2 September 2020

Your Ref: SSD-8636-Mod-2
Our Ref: R/2018/7/E
File No: 2020/384579

New Request for Advice – University of Sydney – Engineering & Technology Precinct – SSD 8636 Modification 2

Proposed Tree Canopy Coverage

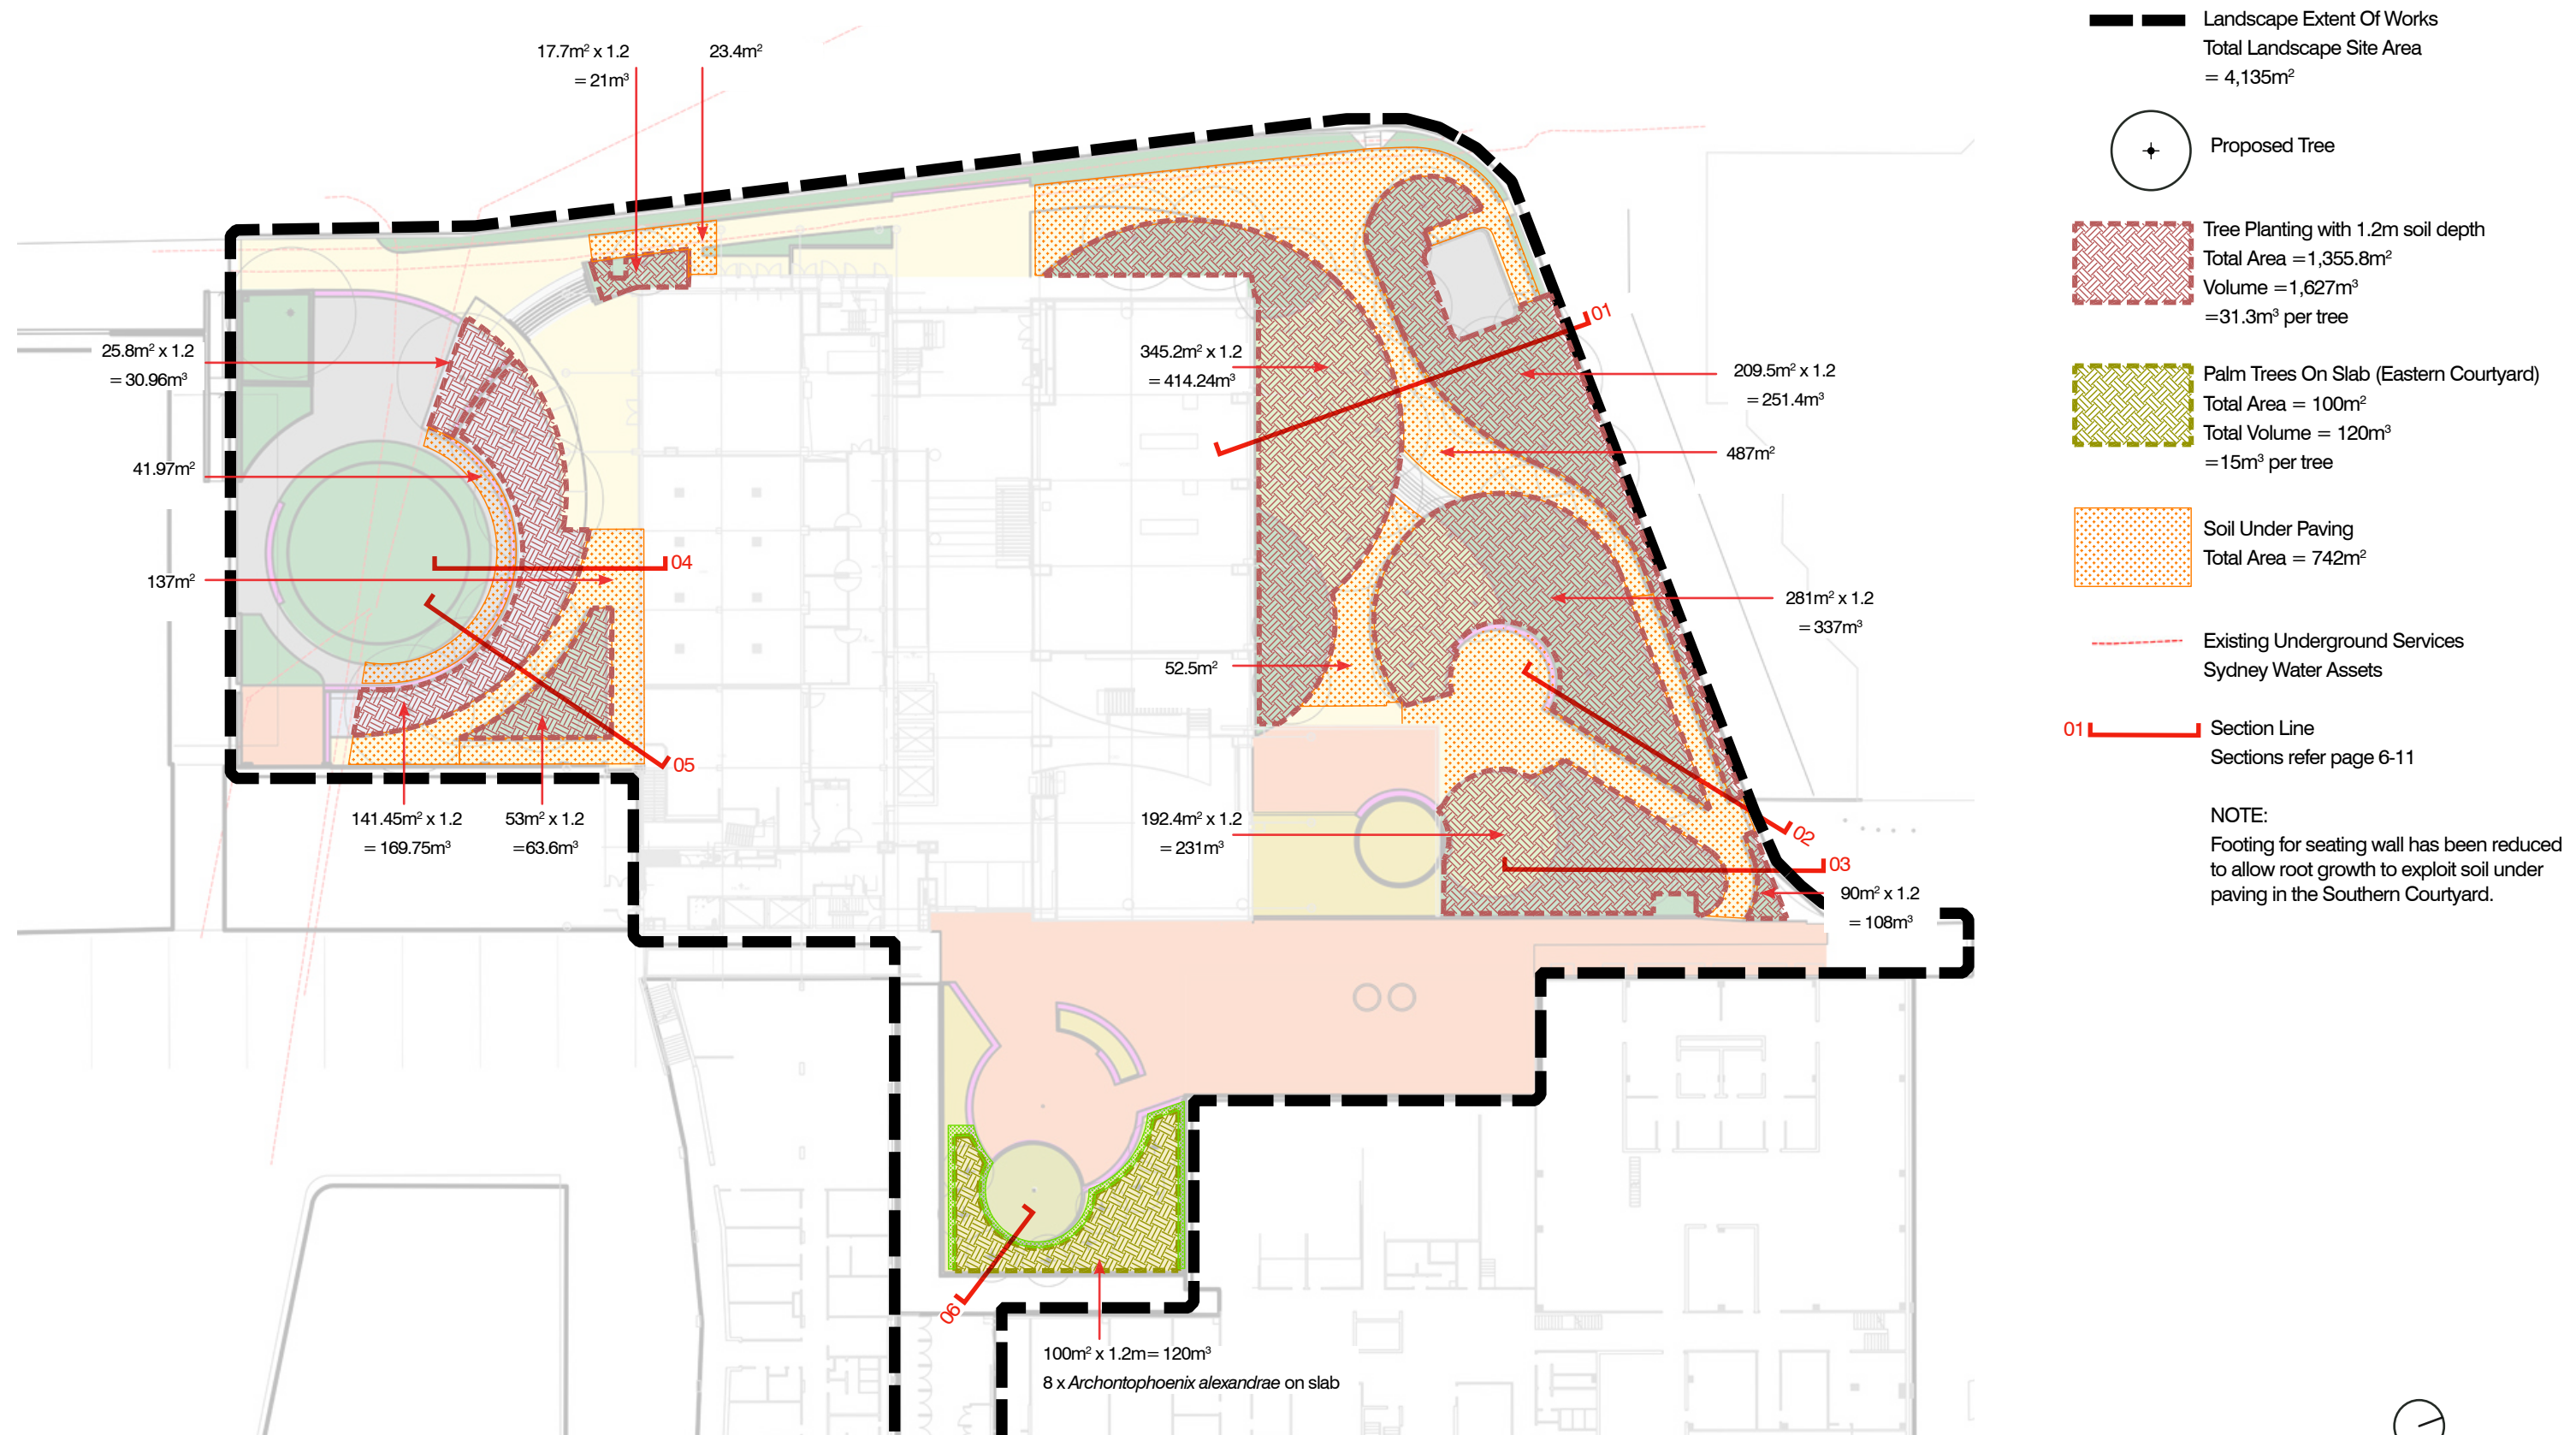
The proposed tree species within the northern landscaped area are predominantly small to medium sized trees that would reach a mature height of 10 metres. The City recommends larger canopy trees with a minimum mature height 15 metres are provided to achieve the 15% canopy coverage in accordance with the Sydney DCP 2012. The proposed raised tree planters on slab will not provide adequate soil depth to support healthy tree growth and do not comply with the Sydney Landscape Code. Consideration must be given to adequate soil availability and space (above and below ground) for all tree species to reach their full genetic potential.

outcome for achieving 15% canopy coverage within 10 years of the completed works, in addition to mitigating the urban heat island effect and mitigating flood water. The City recommends additional larger-canopy trees with a minimum mature height 15 metres are incorporated into the design.

Surfaces Plan 03 Eastern Courtyard

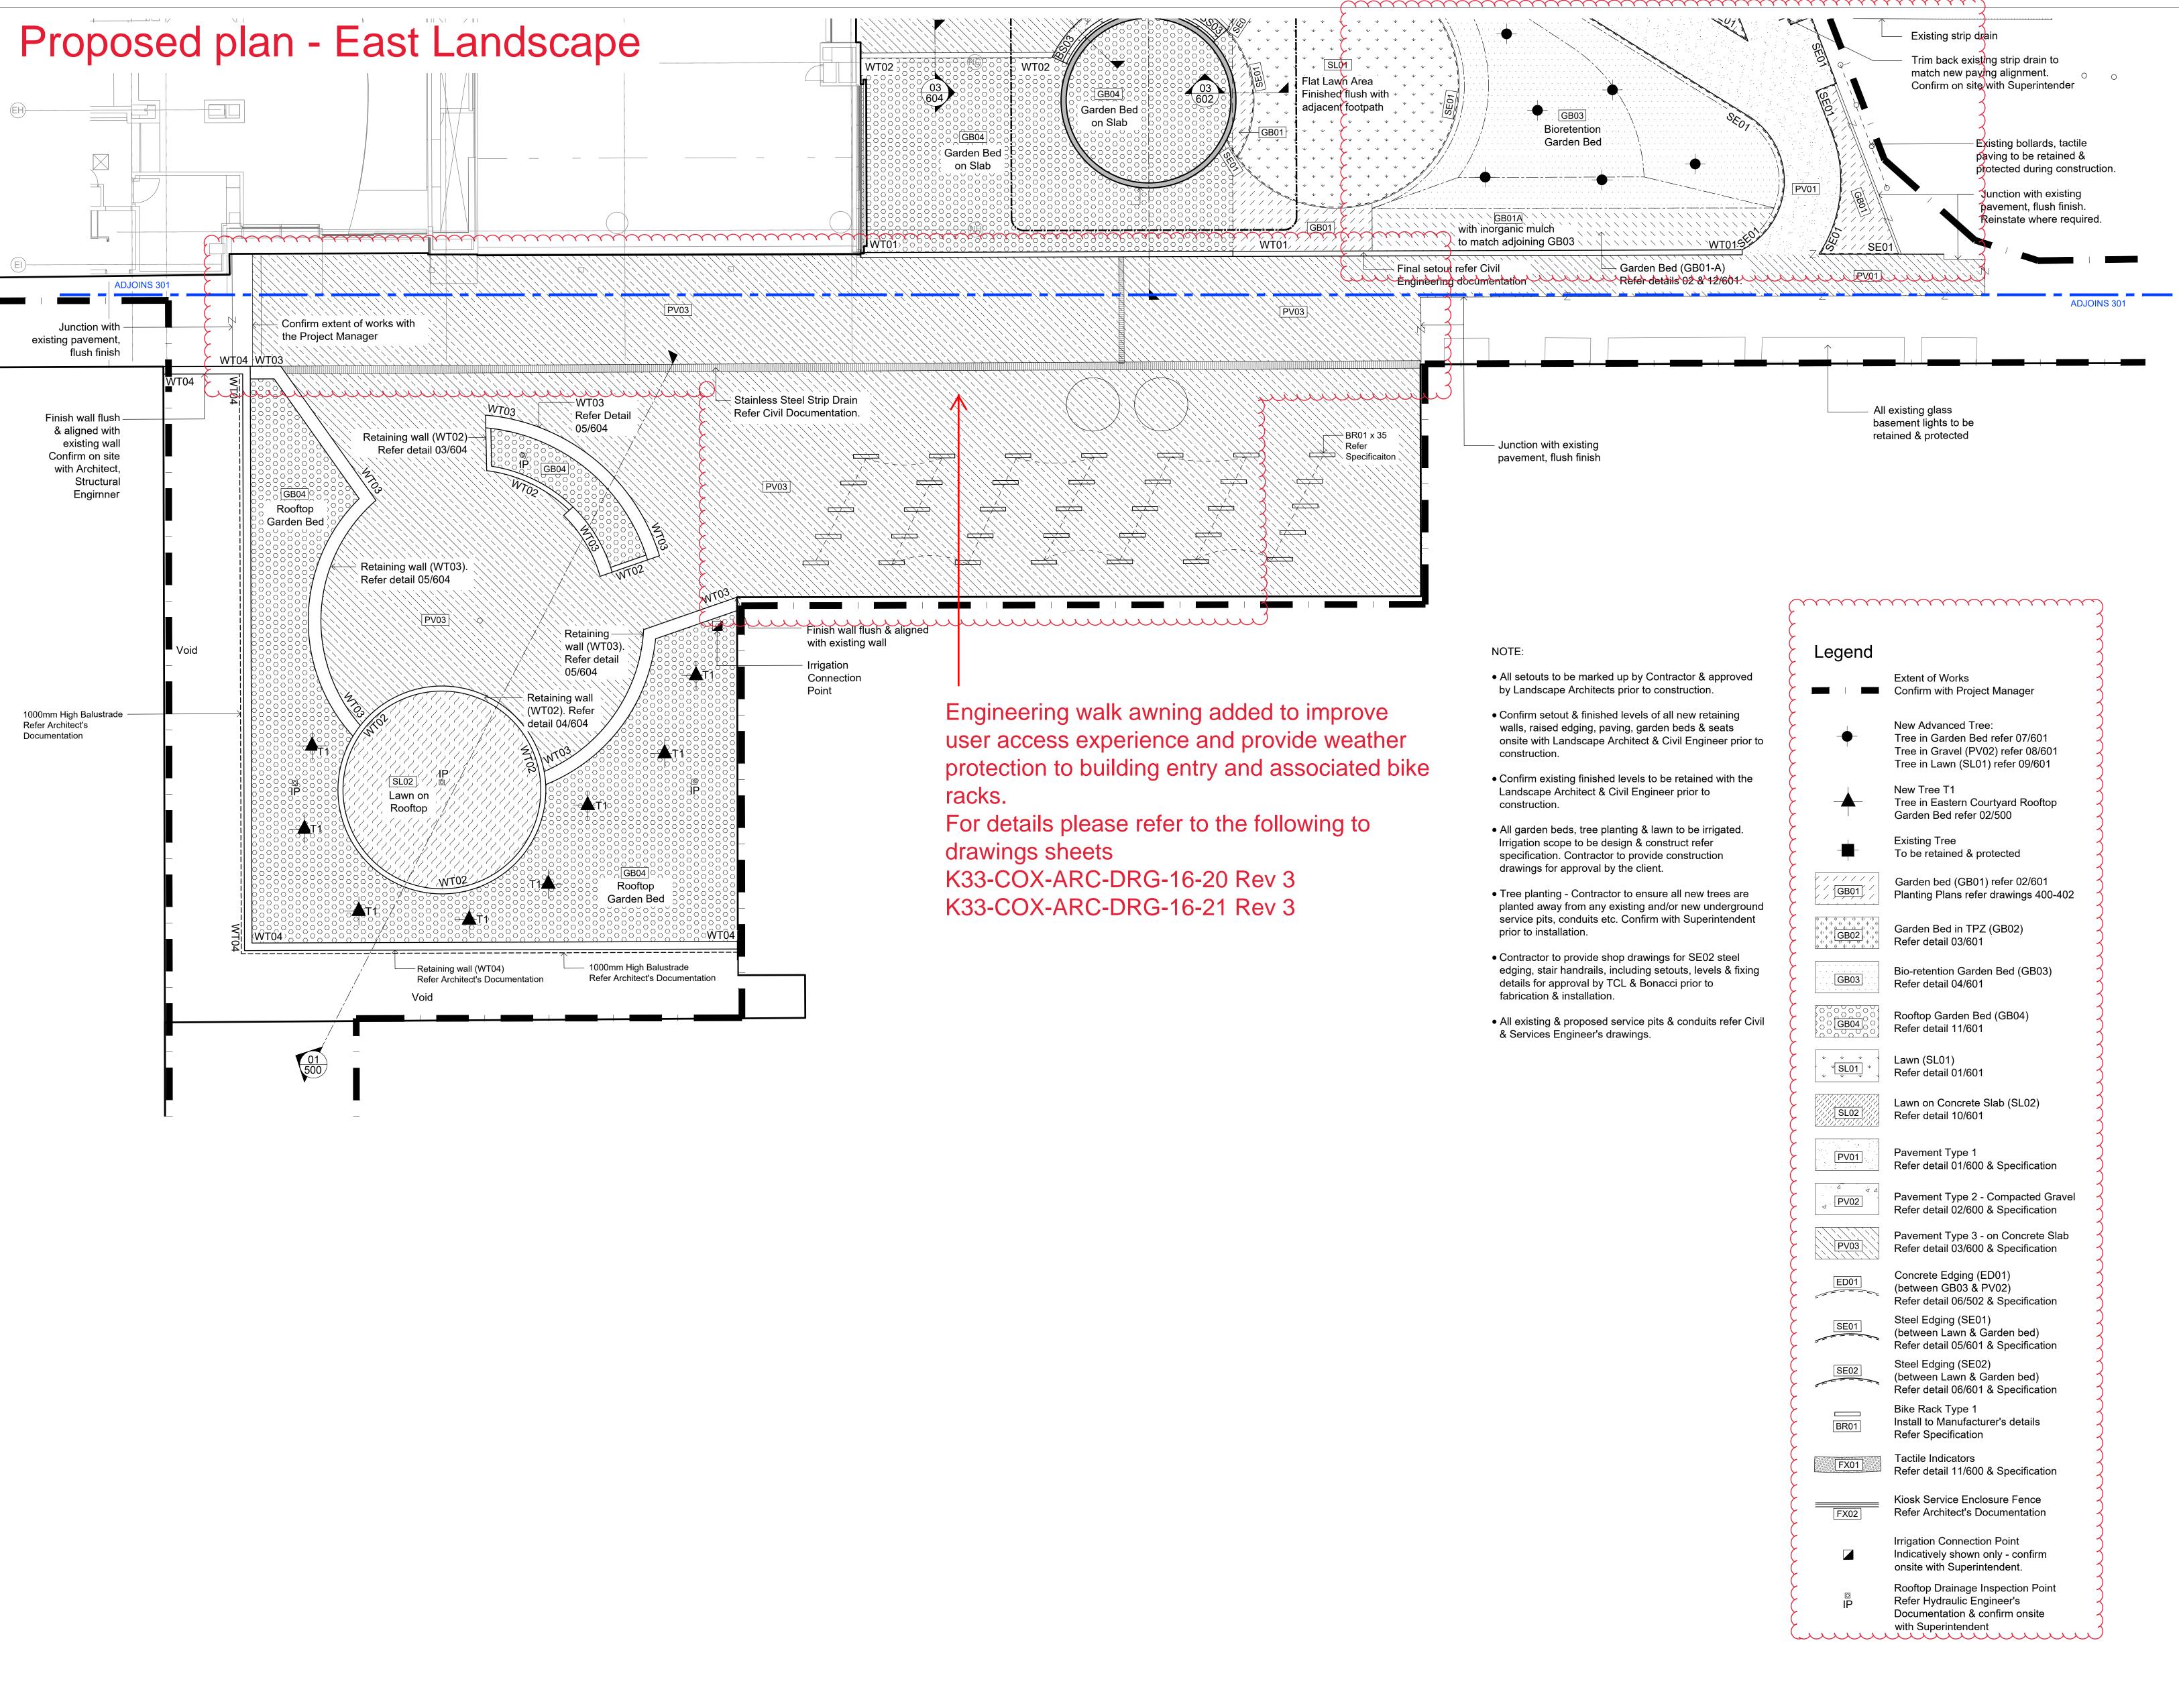
Changes to the East plaza include rationalisation of the layout and addition of a new glazed awning (3.5-4m high) to engineering walk for users accessing the bike racks that segregates the landscape from the building. It's unclear if the seating walls will be accessible for students to sit and learn outdoors or now just a space that's viewed from the building.
